CITY OF ALBUQUERQUE

January 8, 2014

RE: **Shepherd Lutheran Church – 3900 Wyoming Blvd. NE** File # **G20/D036**
Grading & Drainage Plan for Building Permit PE Stamp: 1/02/14

SECTION D-D
NTS

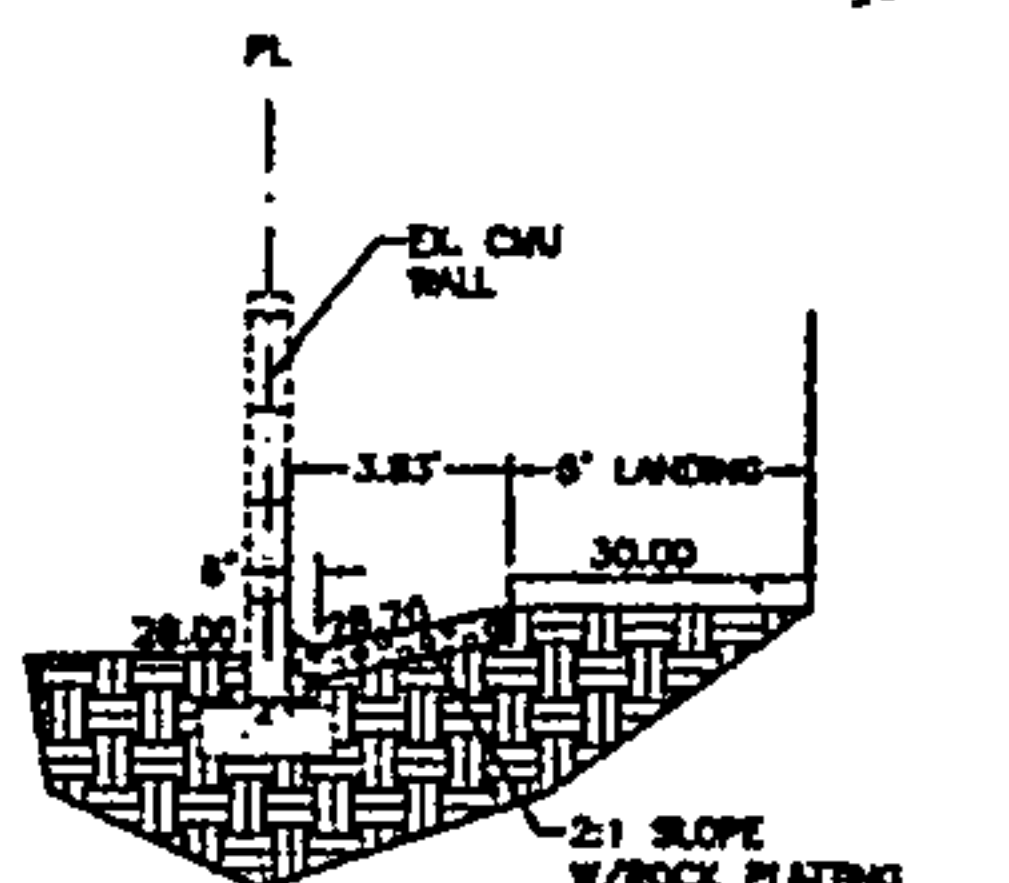
It is acknowledged that the upper layer of material that is shown in Section D-D of the plan (unlabelled) is a drafting error, and is to be disregarded.
